# CITY OF ALBUQUERQUE

**Re: Mountain Mahogany Community School, 5014 4<sup>th</sup> Street NW, Grading and Drainage Plan**

**Engineer's Stamp date 01-13-12 (F14-D062)**

GRADING AND DRAINAGE PLAN (1 OF 2)

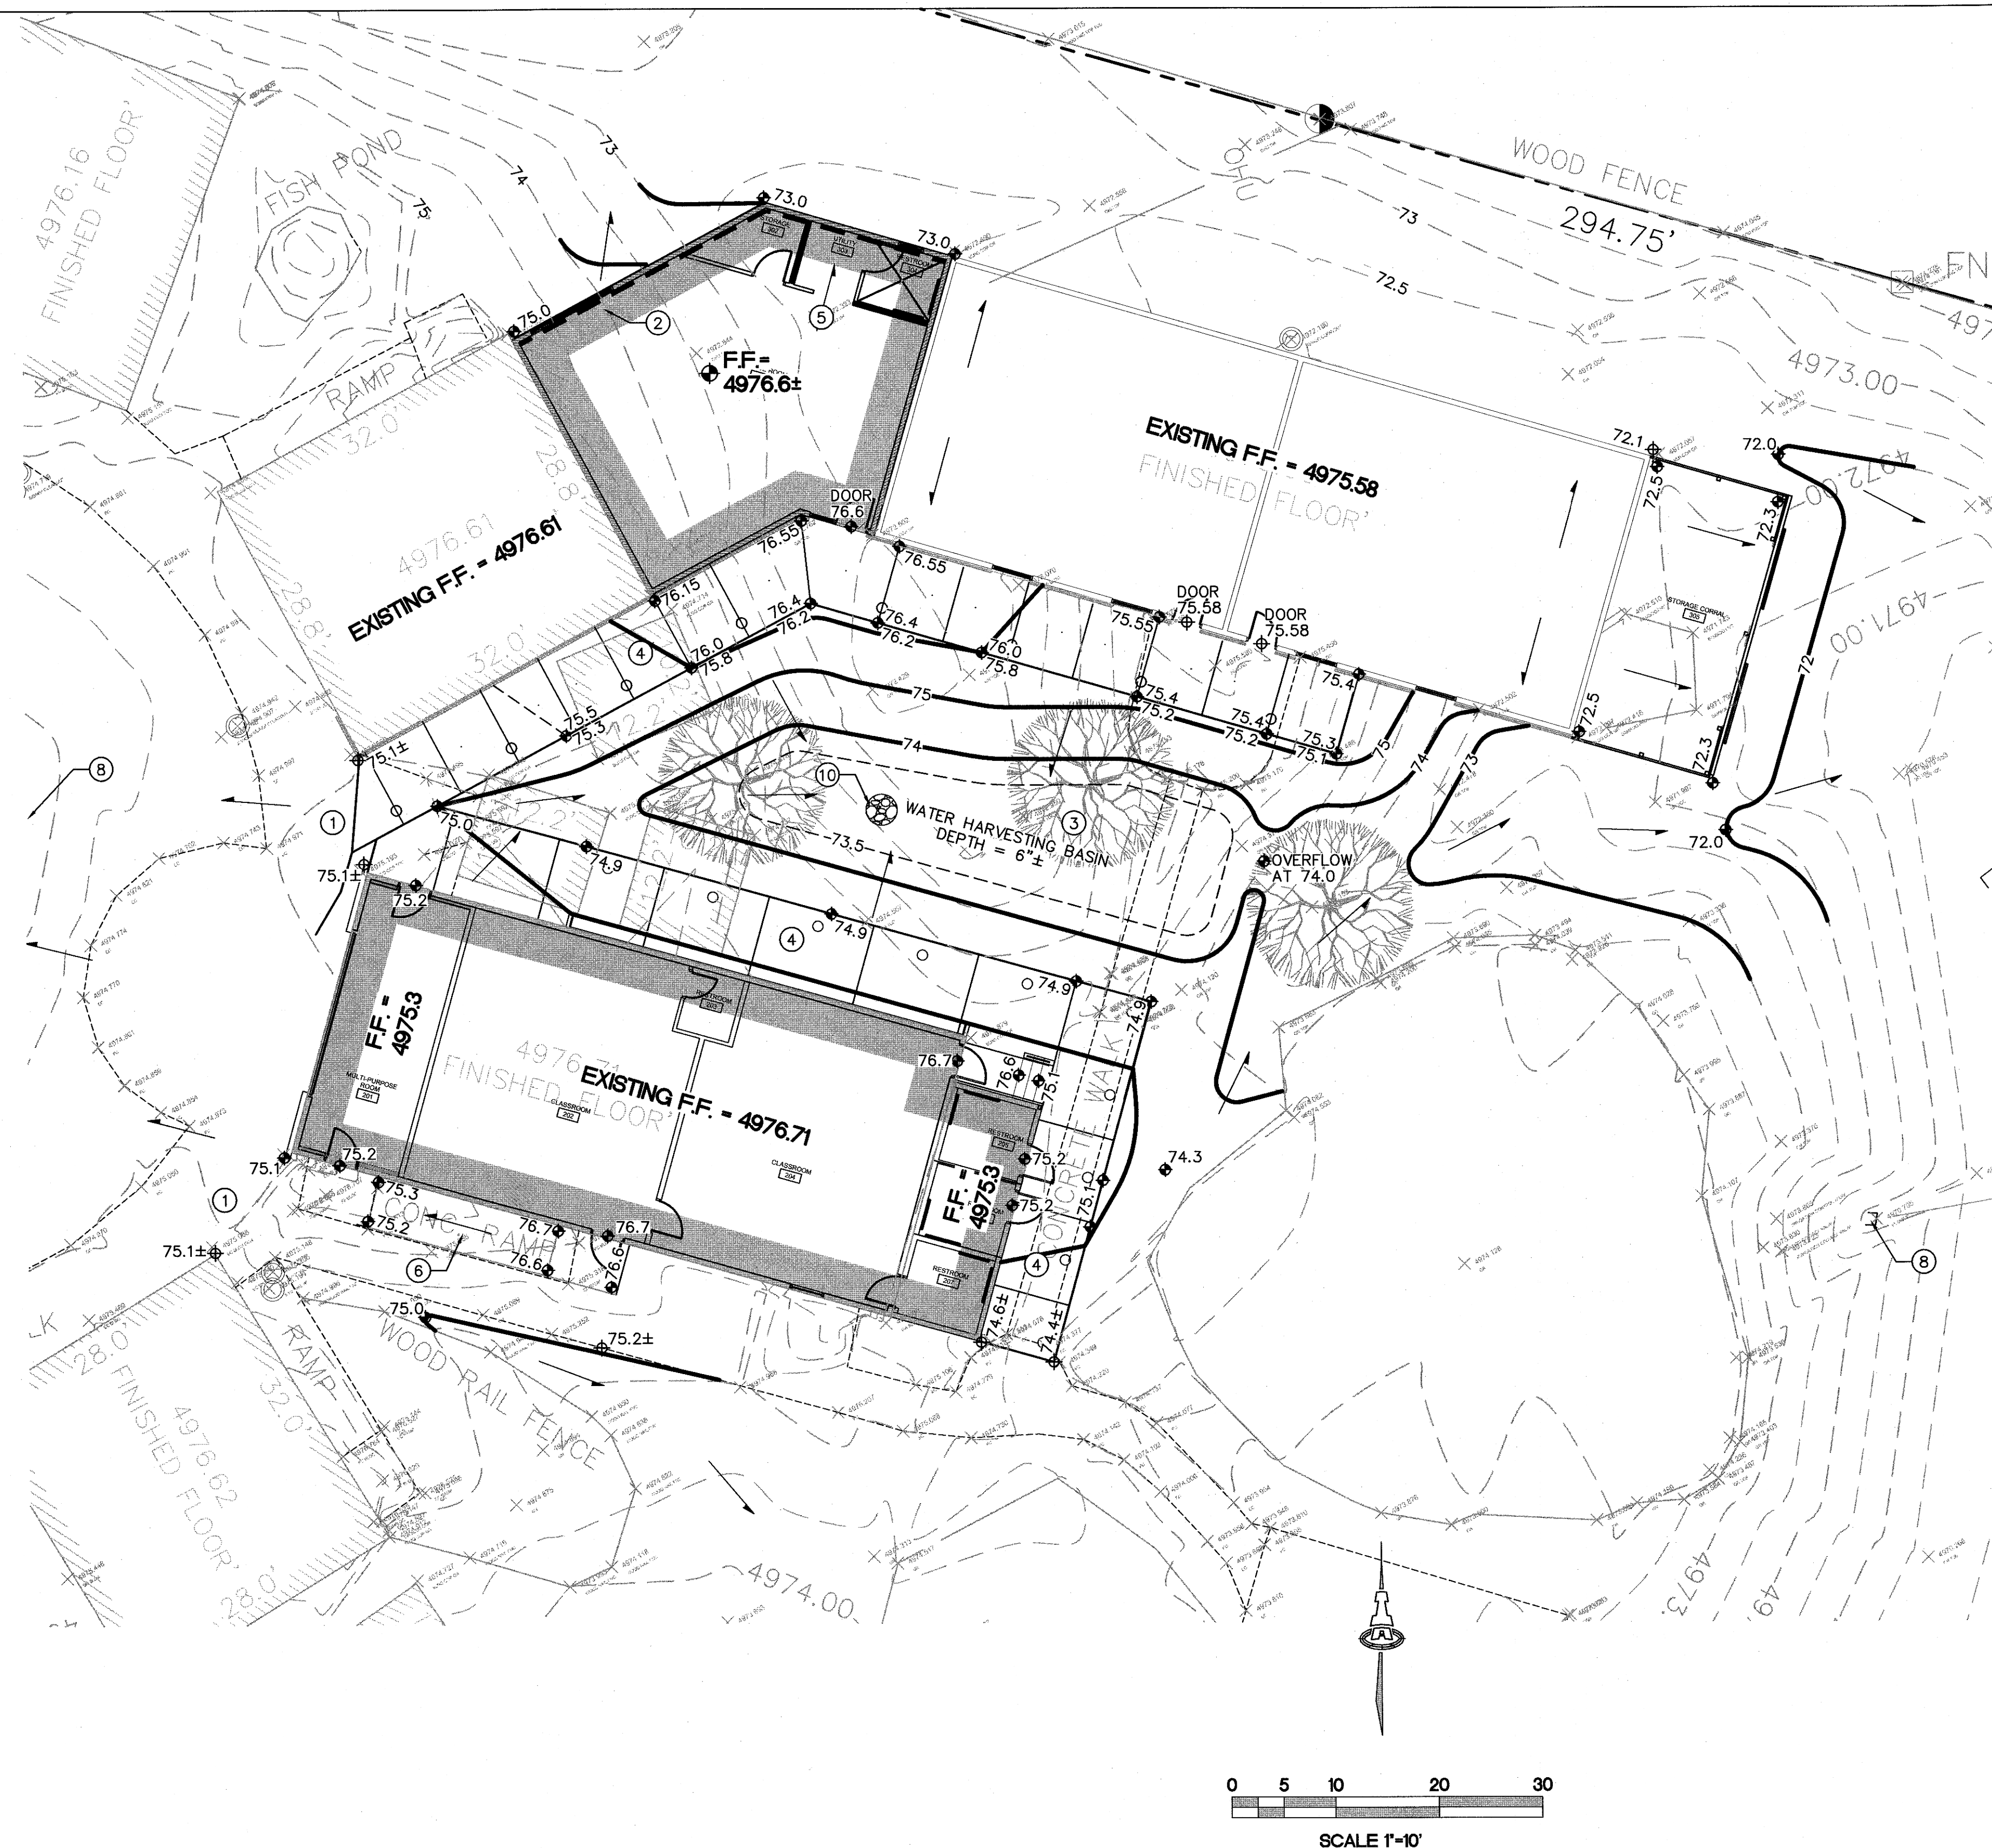
- An approved Grading and Drainage plan is on file for this property and the proposed grading appears to impact the on-site retention ponds that were approved to contain the 100 yr, 10 day storm event.
- One of the existing structures was previously built without a permit and encroaches on one of the approved retention ponds.
- The proposed structures also appear to encroach on another on-site retention pond.
- Provide pond volume calculations to ensure proper water retention is maintained.
